Rezoning Transportation Analysis

Petition Number: #2022-109

Date	Description
11-28-22	First Review (IW)
12-21-22	Second Review (IW)
01-25-23	Third Review (TM)
03-22-23	Forth Review (IW)

TECHNICAL  
DATA SHEET

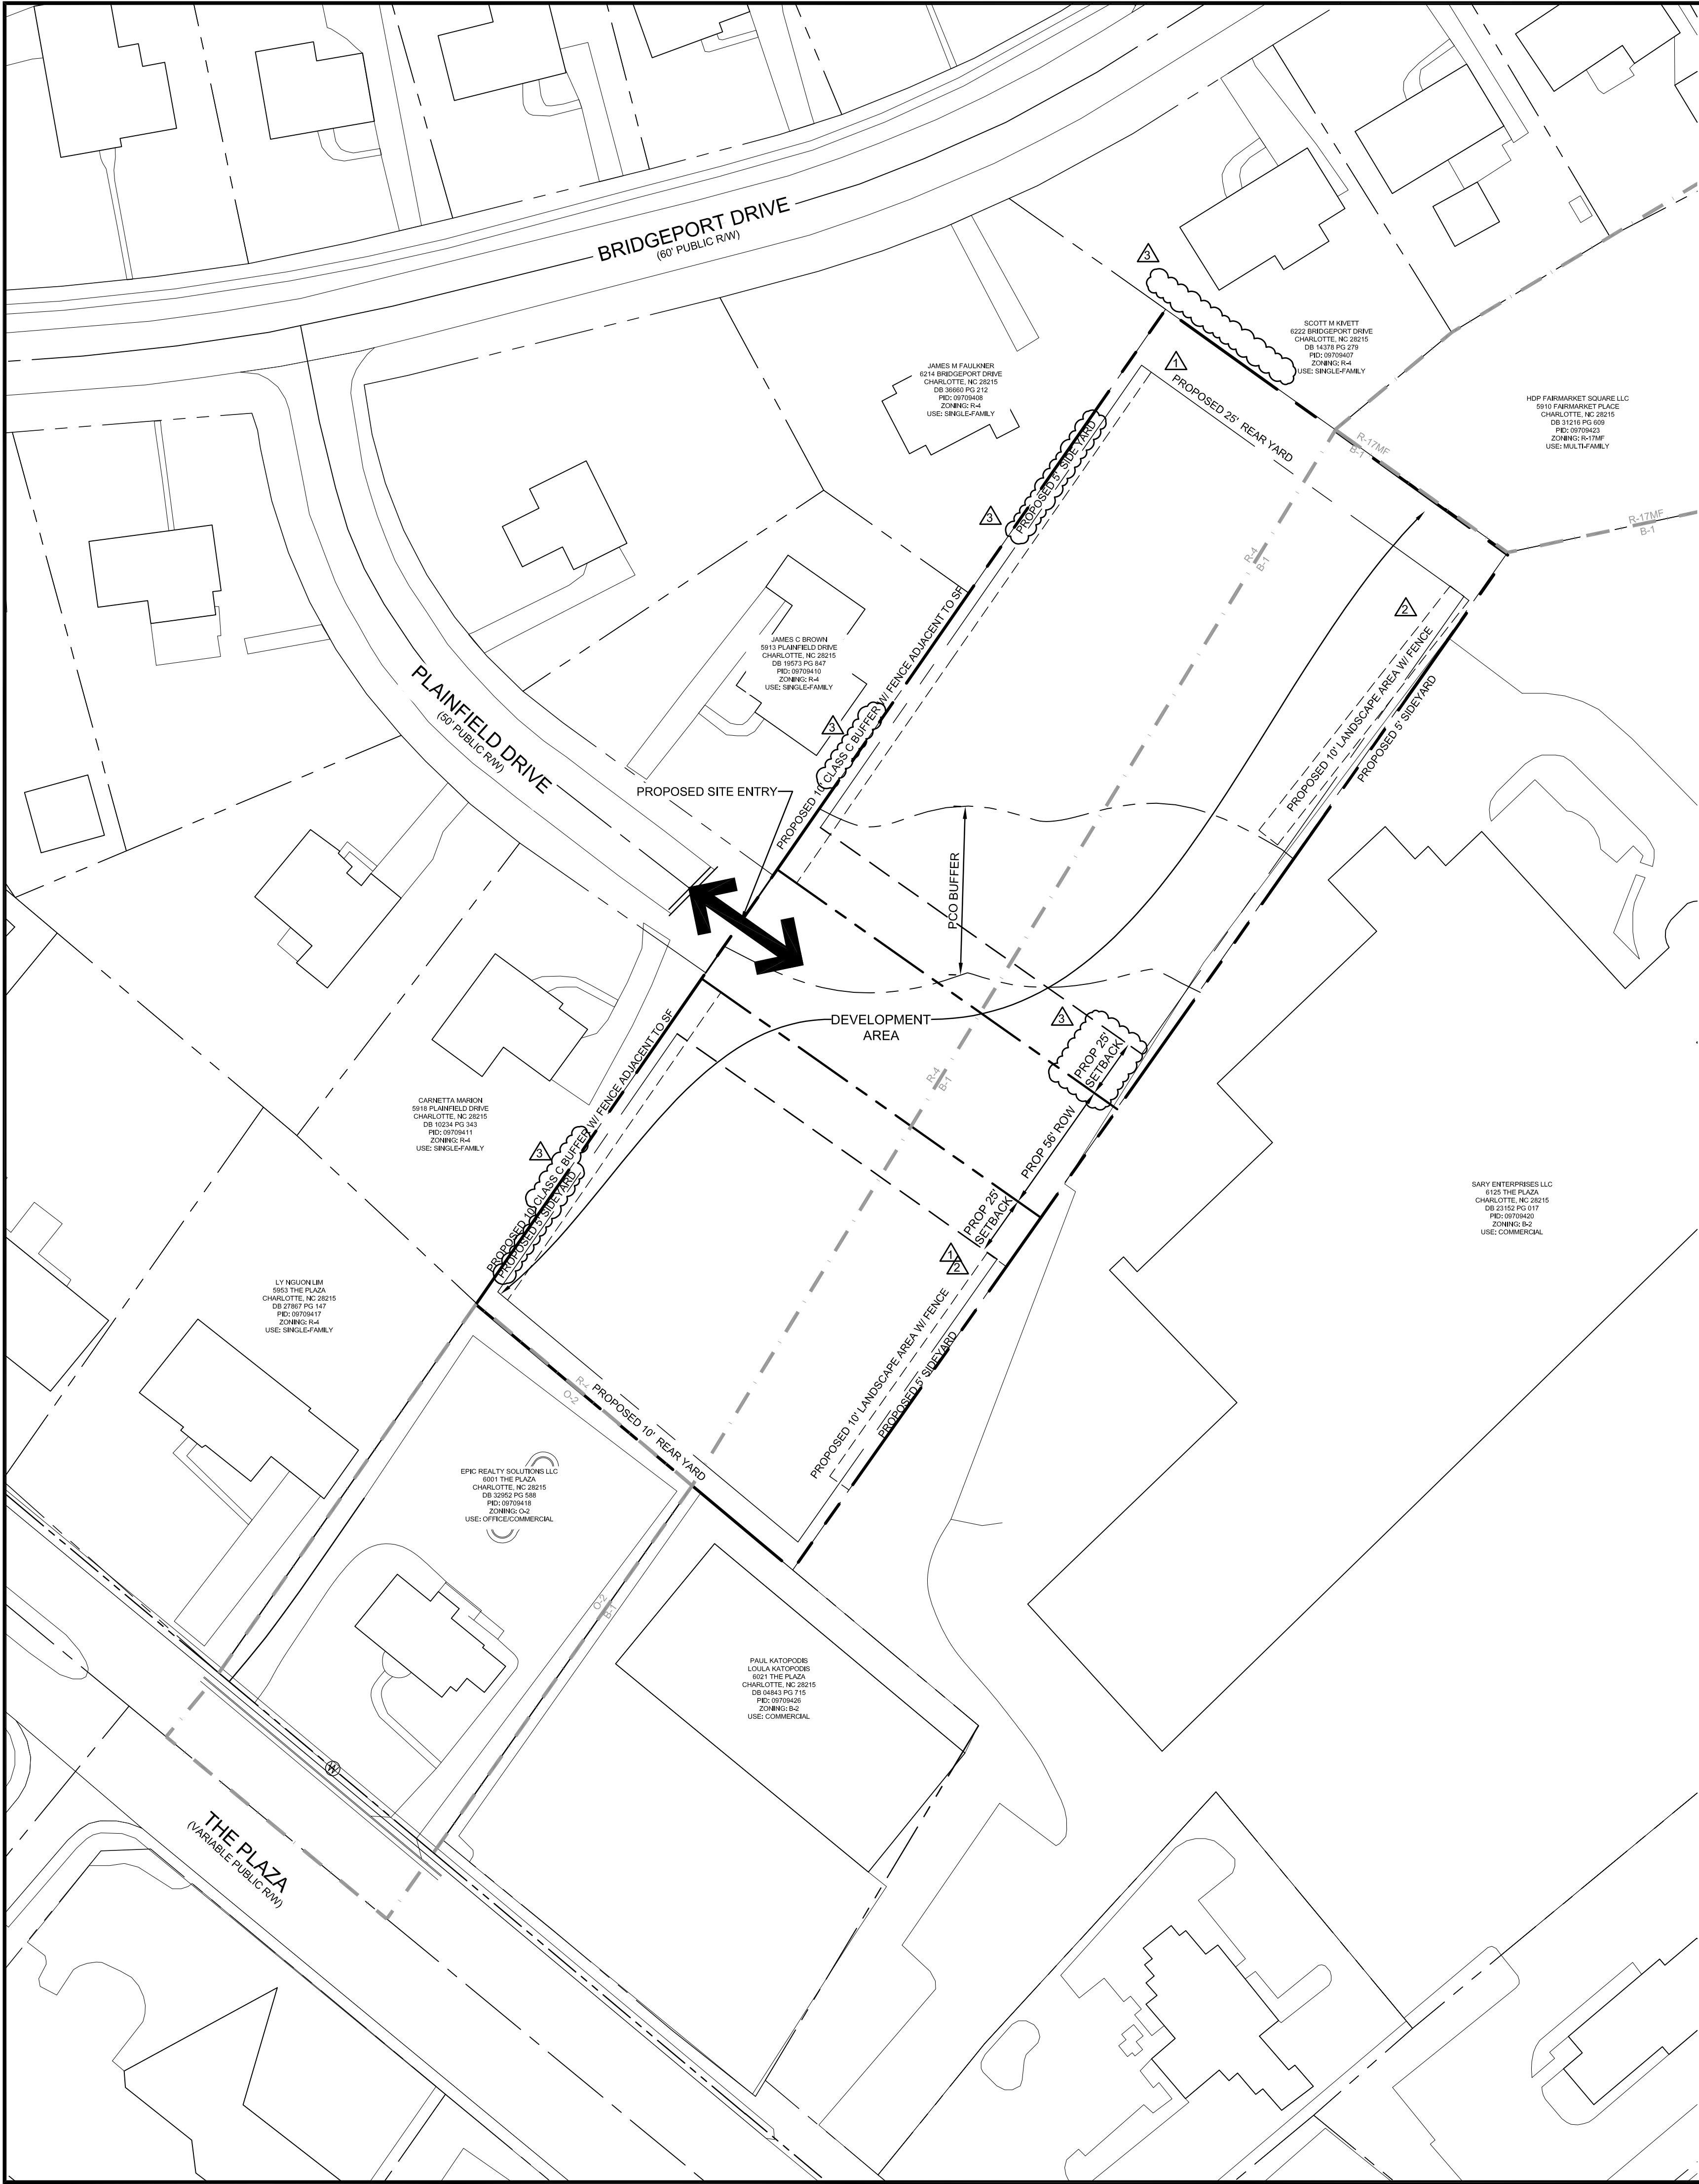
4. The proposed dwelling units exceeds 12 per acre. Per Chapter 20 Subdivision ordinance, site plan and conditional note(s) revisions are needed to commit to construct an 8-foot planting strip, and 8-foot sidewalk along all public roads. The wider sidewalk also meets the Charlotte WALKS Policy.

Reference (CLDSM standard detail U-02) for residential medium street typical.

Outstanding Clarifying Comment 12-21-22: Petitioner should add conditional note stating commitment of 8' planting strip and 8' sidewalk along both sides of all public roads. Reference (CLDSM standard detail U-02) for residential medium street typical section. Potential environmental conflicts to be coordinated during permitting if full section cannot be achieved.
